Alternative Design Review

97 Cumberland Avenue

Design Review by Caitlin Cameron, Jean Fraser, and Alex Jaegerman

5/22/14

EXTERIOR FINISH SCHEDULE	
MATERIAL TYPE	MATERIAL DESCRIPTION
AL1	Aluminum Clad Window Frame
M1	Cold Formed A606 Steel Panel Siding - 20" x 10"
PW1	Painted Wood Trim
ST1	Acrylic Stucco Over Rigid Insulation
WS1	Vertical Shiplap Siding

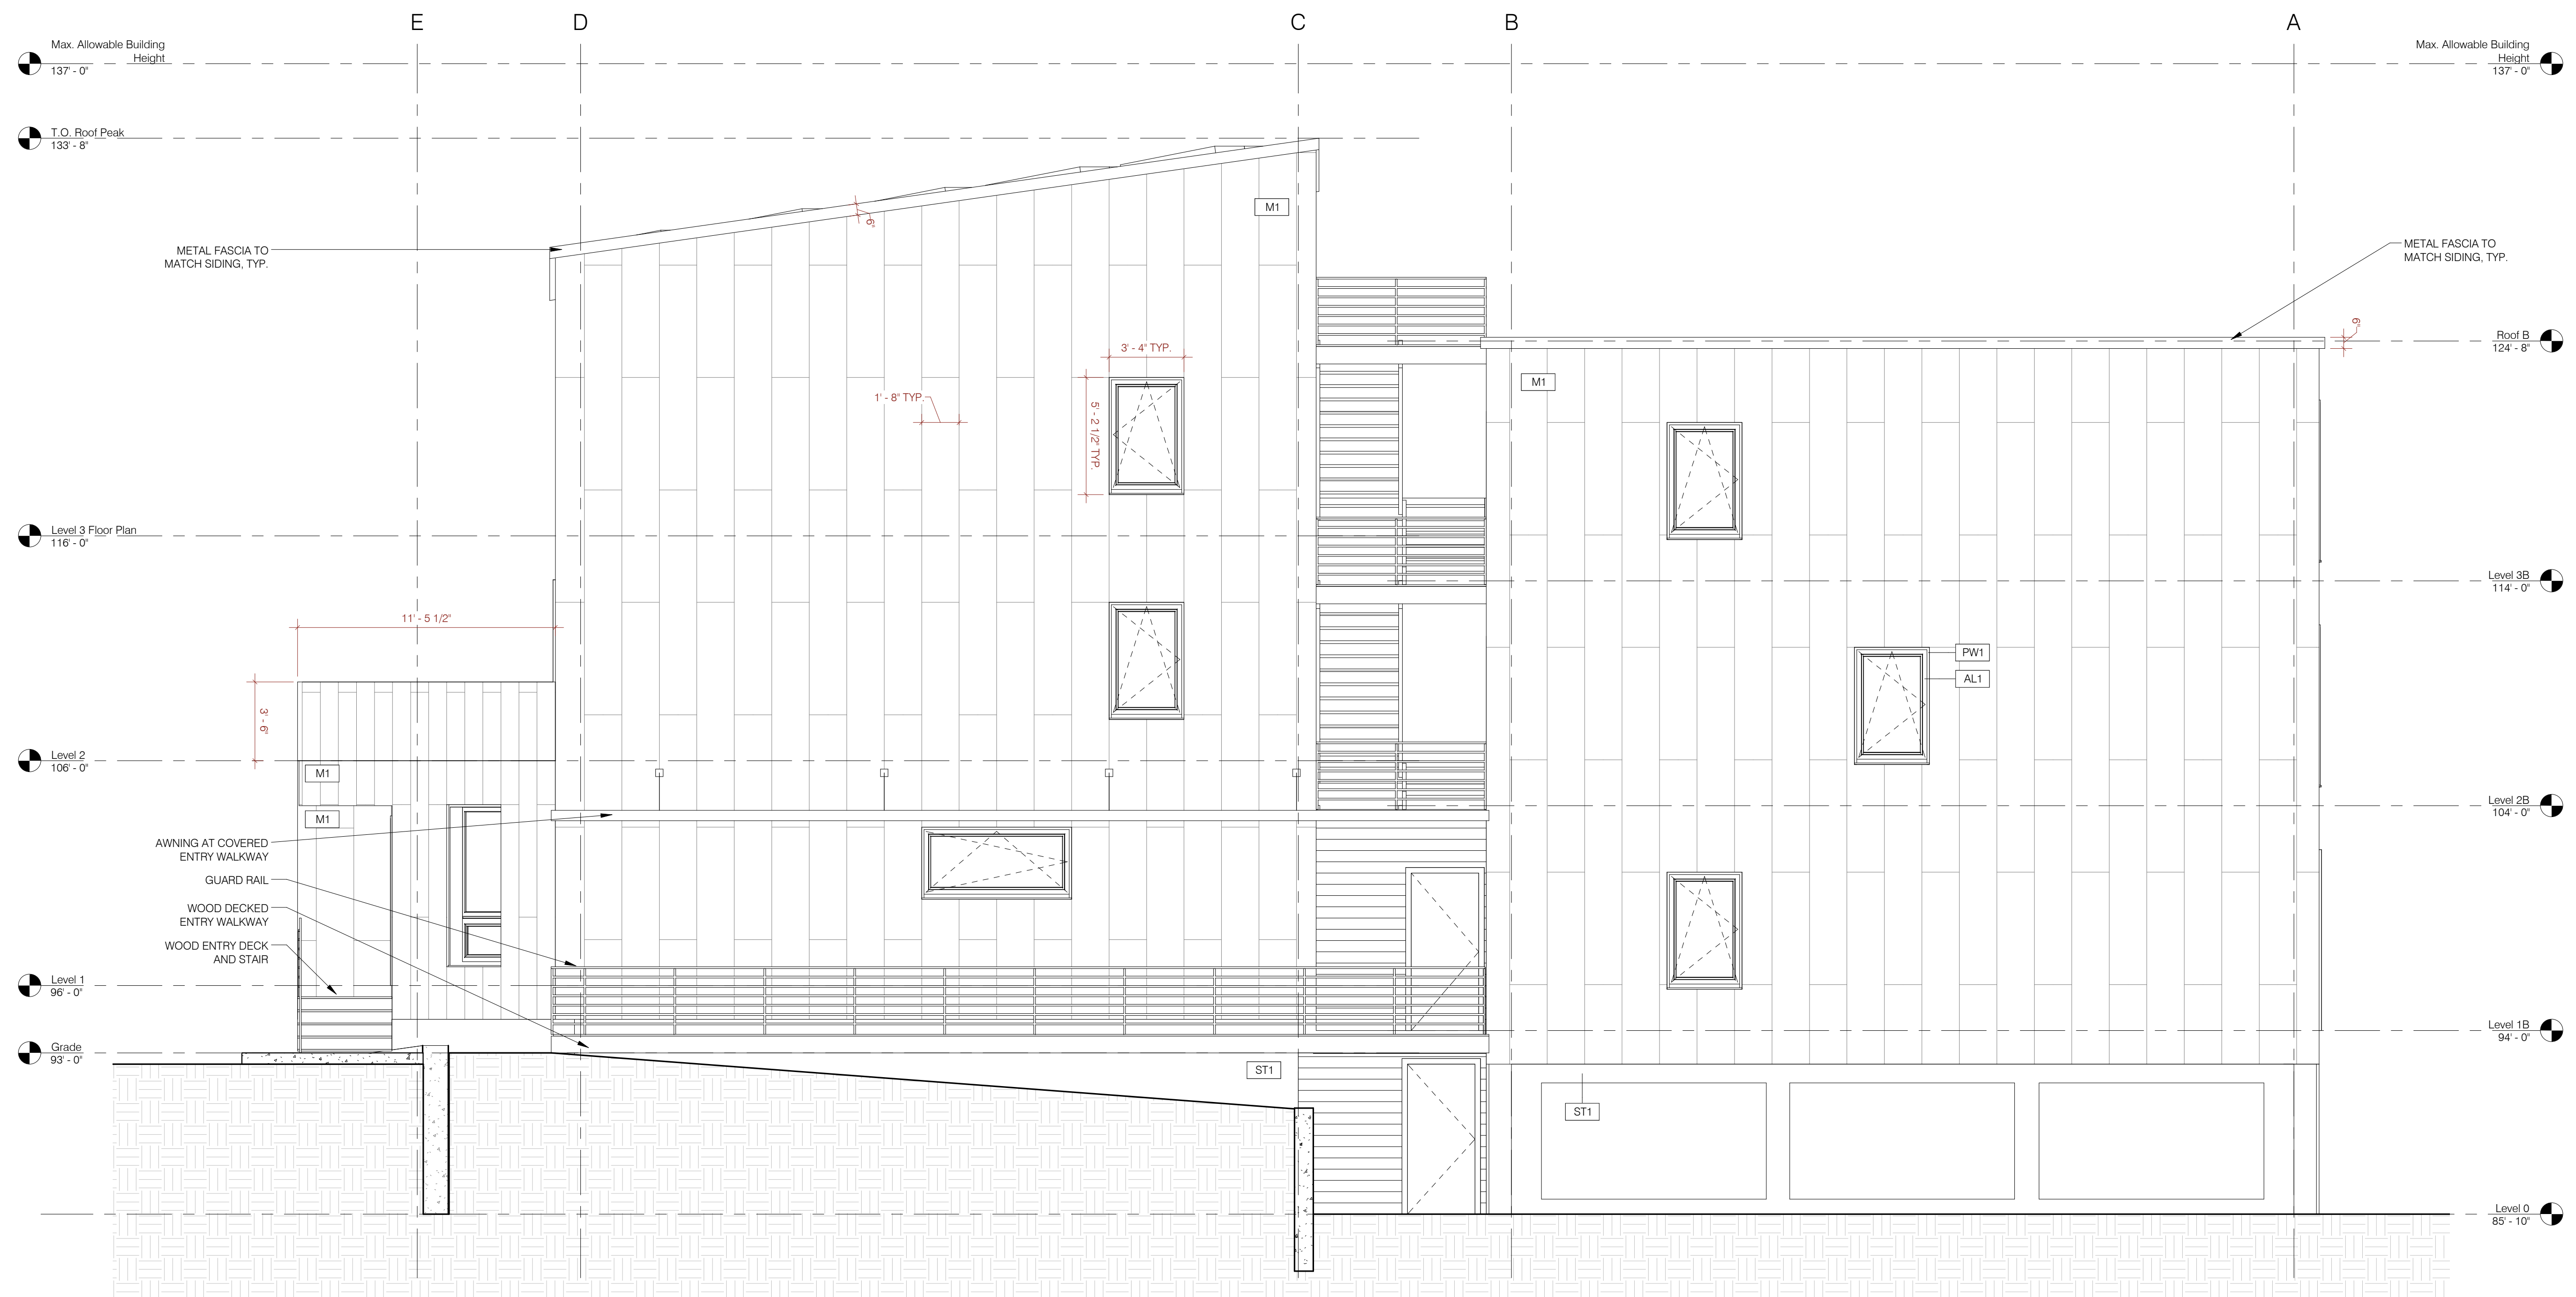
- d. Proportion and Scale: The project maintains the proportions and scale found in the surrounding buildings with a three-story façade. Front and side entries are covered and provide human-scale elements. The front façade is further broken up into two forms, the projecting form nearest the street is one-story tall.

- e. Balance: The façade composition is balanced employing local symmetries with an appropriate and pleasing proportion of window openings to solid façade.

- f. Articulation: The building design is successful in creating a visually interesting and well-composed façade on Cumberland Avenue as well as towards Washington Avenue with the use of covered porches, window types, emphasized entries, and detailing such as green screen and window reveals.

- g. Materials: Although the project uses a material unique to the context, the design reviewers found the material to be harmonious in color, texture, and authenticity with the neighborhood material palette which tends towards red brick industrial/commercial buildings and brick-based and clapboard-sided residential. The red finish of the metal compliments the depth, texture, and color of brick while the use of planks provides a rhythm on the façade similar to clapboards.

- The majority of Standards within each Principle are met.
- On the topic of massing, the roof form of the proposal is unique to the neighborhood and deviates from two standards to do with roof forms and roof pitch. However, four of the six standards within that principle were met and therefore the deviation in roof

forms is allowed by the Alternative Design Review. In this case, the roof forms proposed are integral to the function of the solar array.

- On the topic of articulation, this project does not use the same type of detailing found in the context (pronounced cornices, railings, eaves and rakes), however, the design does meet the intent of the standards according to its own aesthetic language incorporating articulation with window reveals, cohesive window types, porches/decks, and an emphasized main entry; the result maintains a visual cohesion.
- On the topic of materials, the proposed exterior material is a metal panel cladding in a rust-red finish. While the material is unique to this neighborhood, the reviewers felt the color, texture, and use of the proposed material is harmonious with the surrounding material palette. The standards call for the materials to be harmonious, not identical, and to be used in an authentic way.

- a. Scale and Form: The project must mediate between the scale and form of the residential buildings (mostly two and three-story single family with gable roofs and triple-decker with flat roofs) as well as the industrial and commercial scale and forms of Washington Avenue. The Cumberland Avenue façade maintains the width and height of the surrounding residential buildings. The façade visible from Washington Avenue is broader and in keeping with the larger scale of that corridor.

- b. Composition of Principal Facades: The principle façade on Cumberland Avenue keeps the local symmetry of the main entry similar to the houses surrounding it with a covered porch. Where this project differs from its neighbors is the further setback of the full height of the building.
